**Request for section 75W Modification to MP10\_0166 Redevelopment of the North West  
Precinct Royal Prince Alfred Hospital Campus, Camperdown**

On 4 February 2013, the Deputy Director-General approved, on behalf of the Minister for Planning and Infrastructure, the redevelopment of the North West Sector of the RPA Campus for a new seven (7) storey hospital building and associated parking landscape and roadwork. Since that approval, some minor design changes have been necessary to accommodate the increase in size of courtyards in the Level 3 Acute Mental Health Inpatient Unit and Level 4 Female High Dependency Unit. This will enable these spaces to meet Health Facility Guidelines based on request from Ministry of Health and provide a much better outcome for patients. The design of the courtyards will cantilever past the main façade of the building and overhang the private hospital road at the rear but still within the boundary of the Local Health District's (LHD) land.

DEPARTMENT OF PLANNING SUBMISSION
SITE PLAN

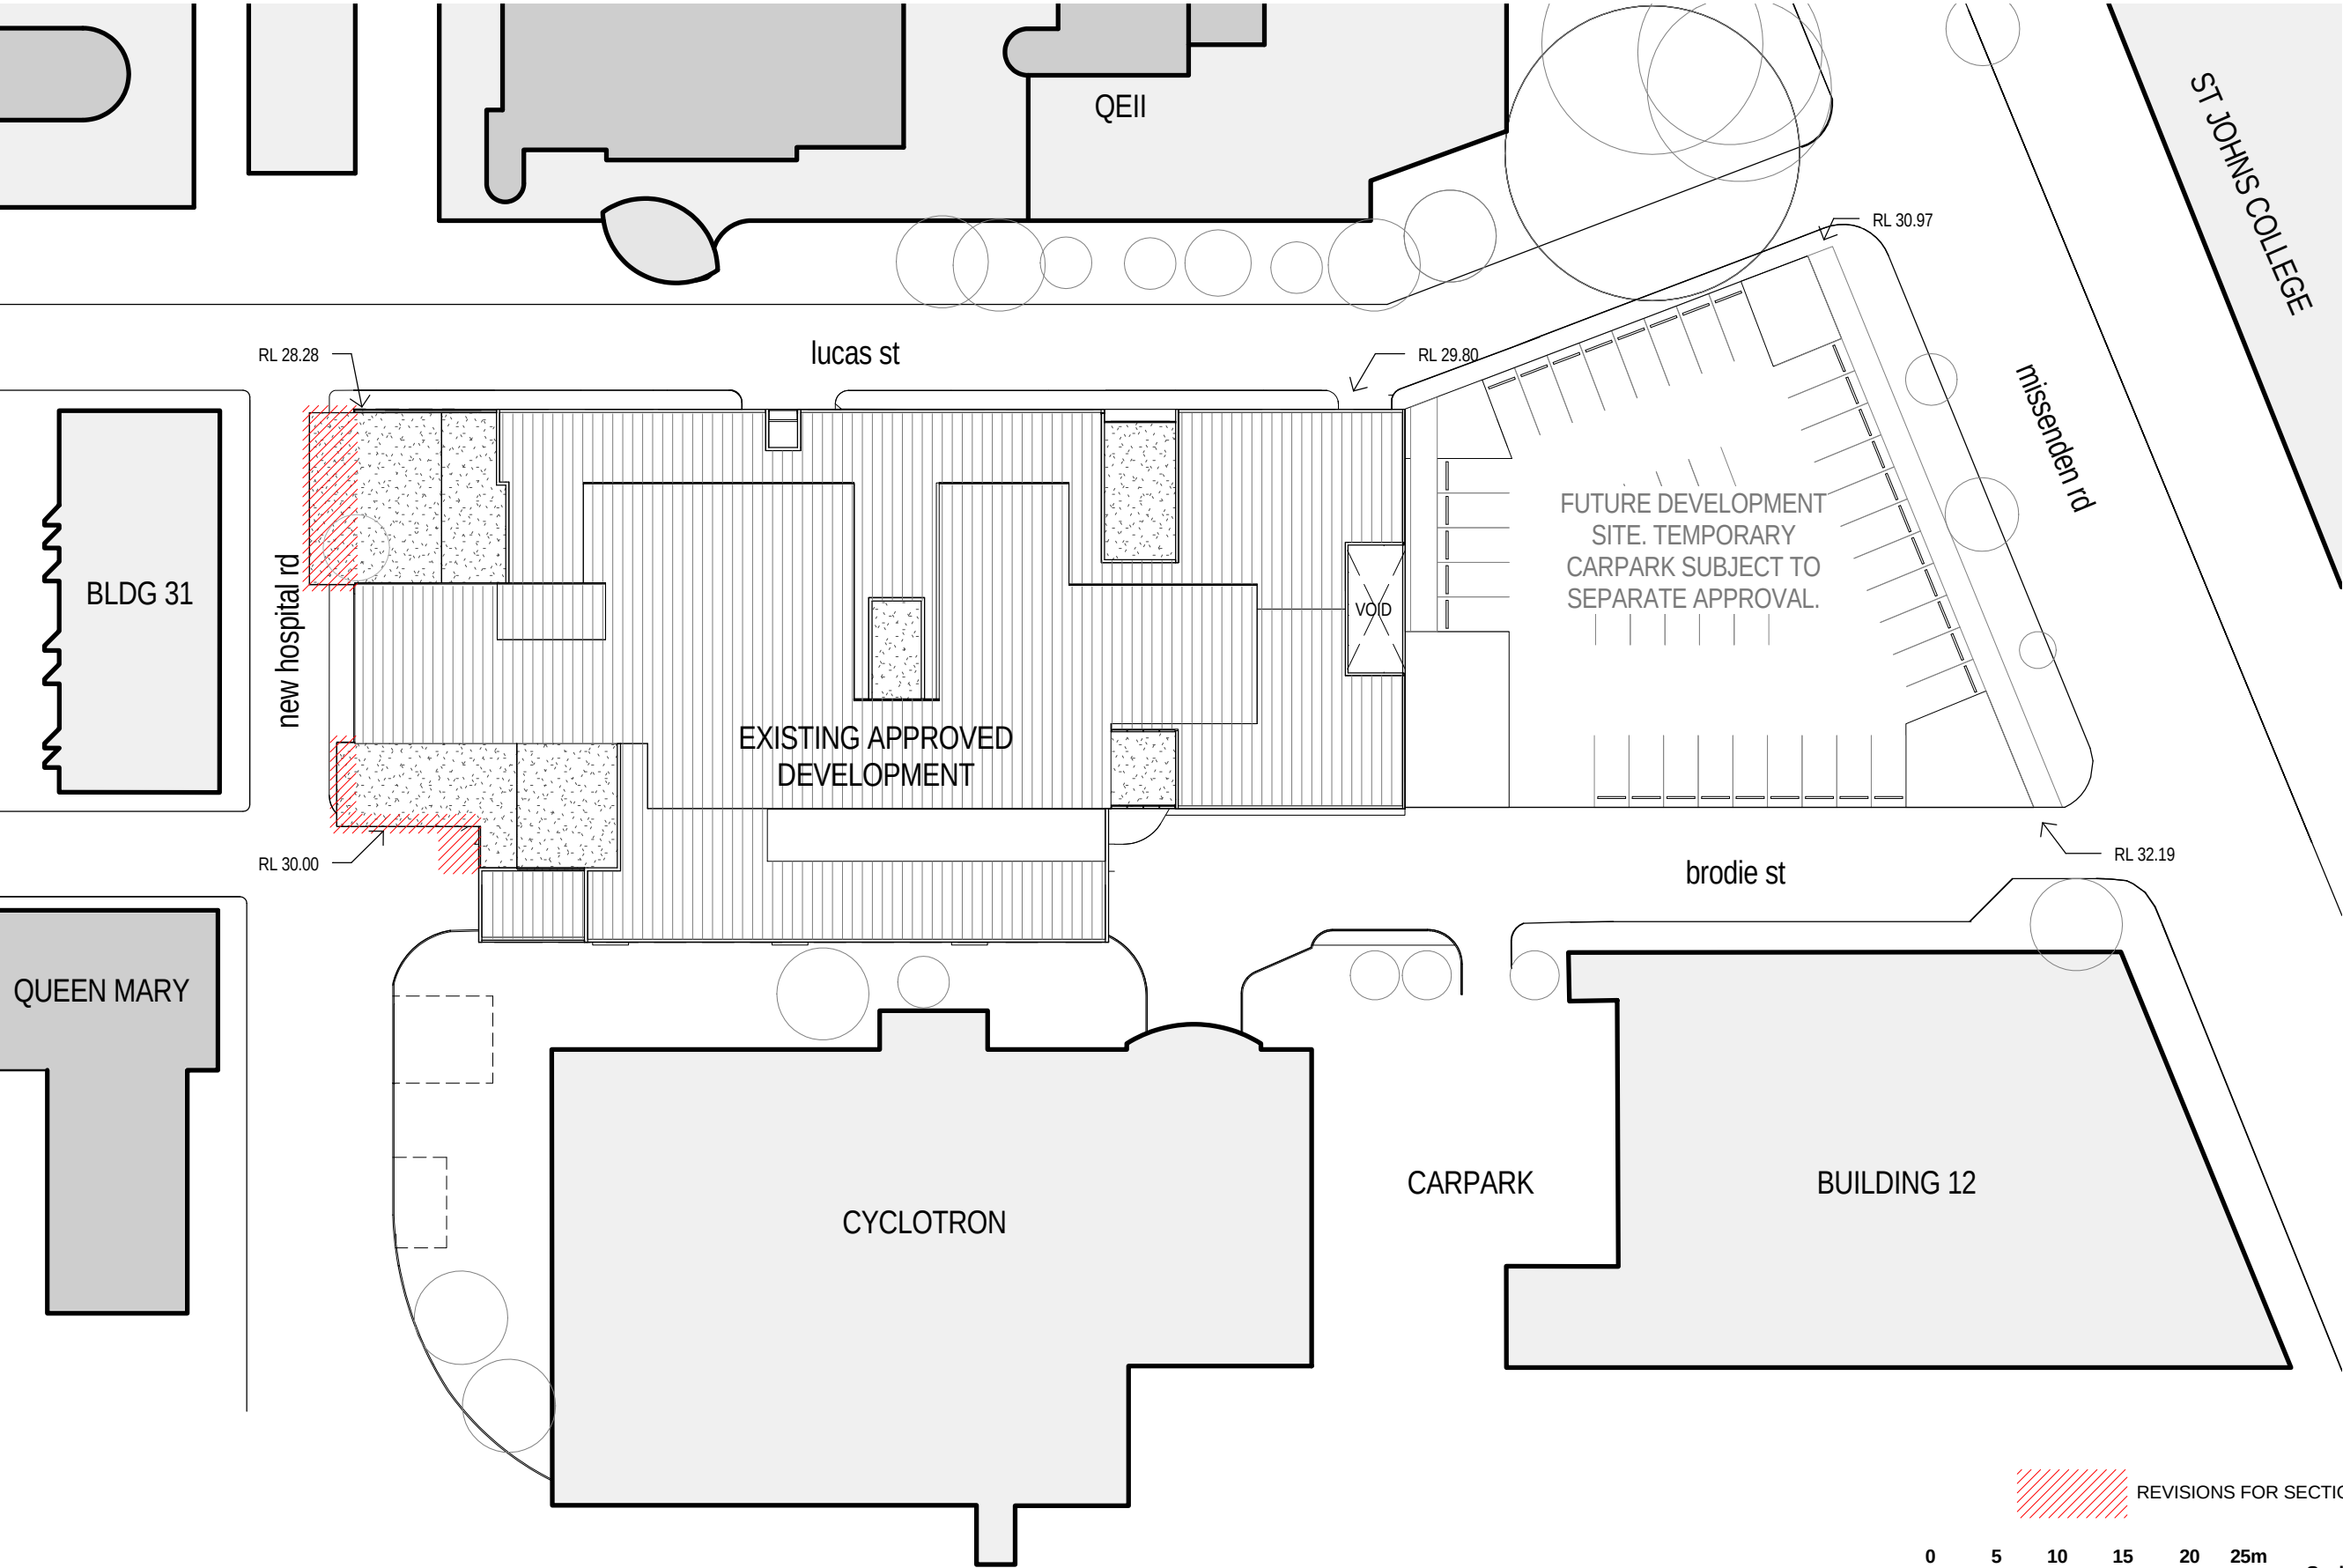
Both amendments are considered to be minor and will not have any environmental impacts on the immediate or general environment. Drawings showing the revised designs are attached.

DEPARTMENT OF PLANNING SUBMISSION
GROUND LEVEL PLAN
ROYAL PRINCE ALFRED HOSPITAL
North West Precinct Project, Camperdown

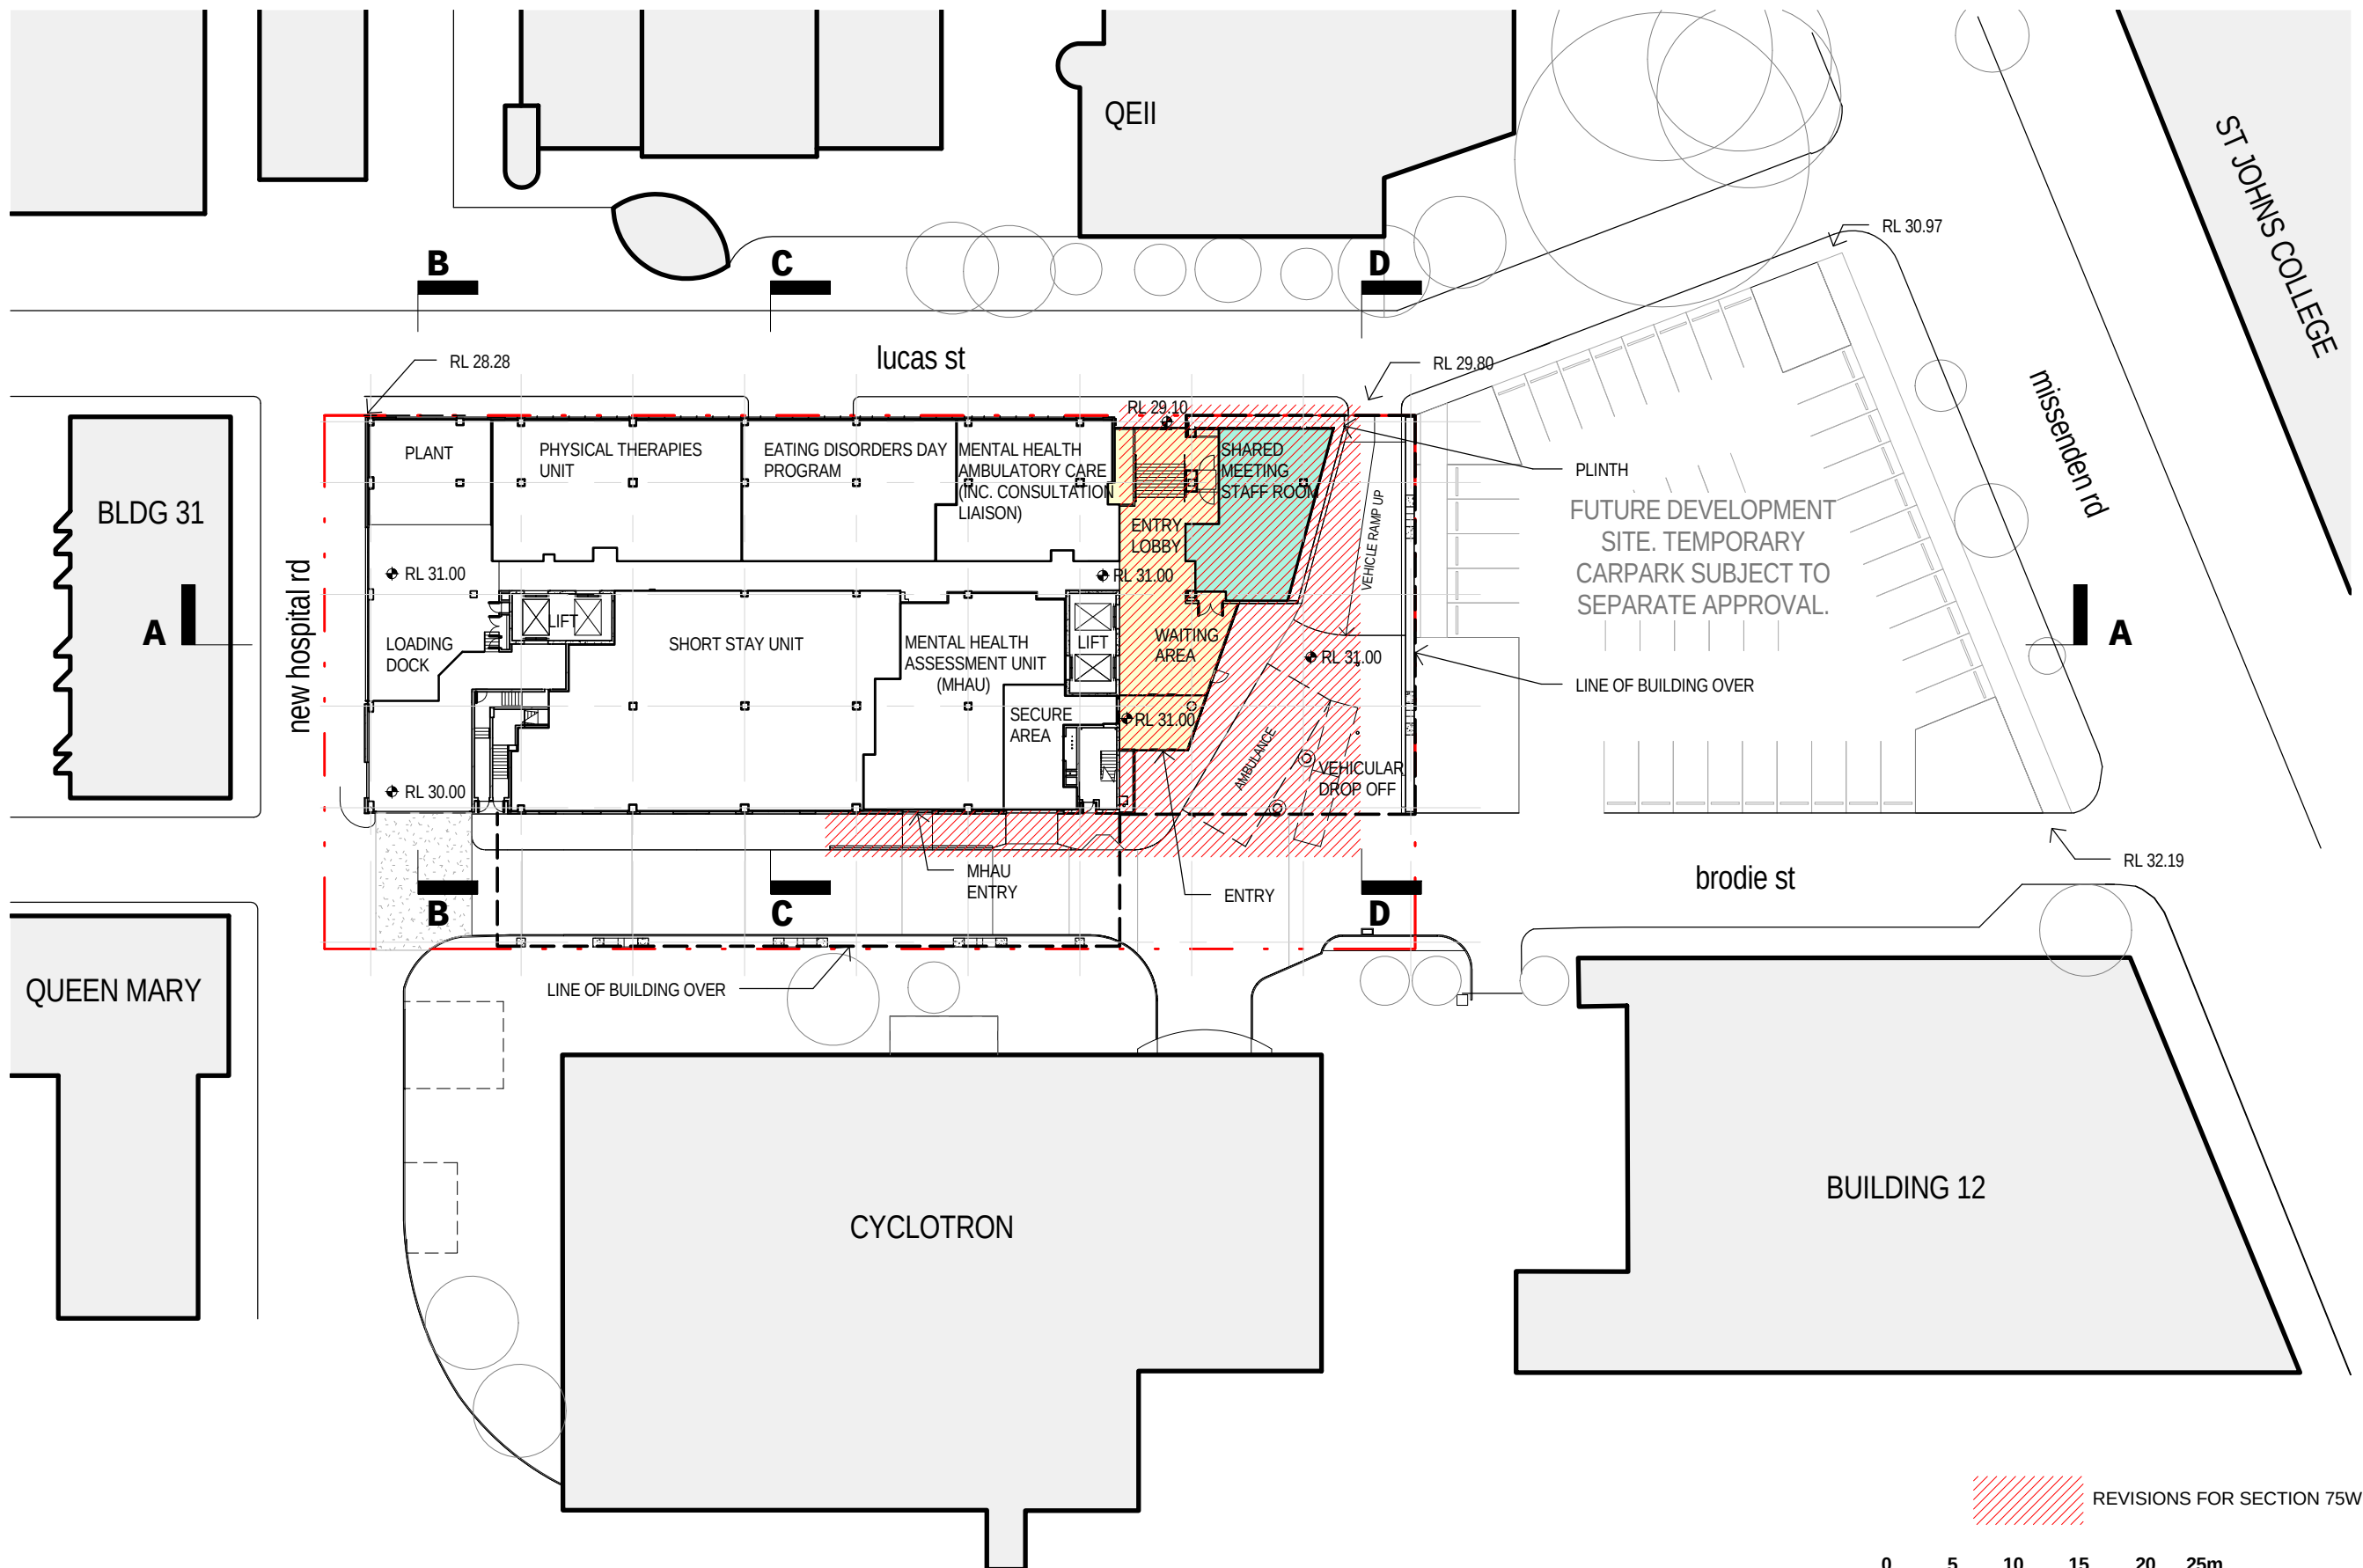
In addition, the ground floor building entry and vehicle drop off and been modified to accommodate a dedicated disabled platform lift in lieu of a ramp as part of the vehicle entry. This solution is in line with the Access consultant's recommendations and allows for a better overall solution in terms of constructability.
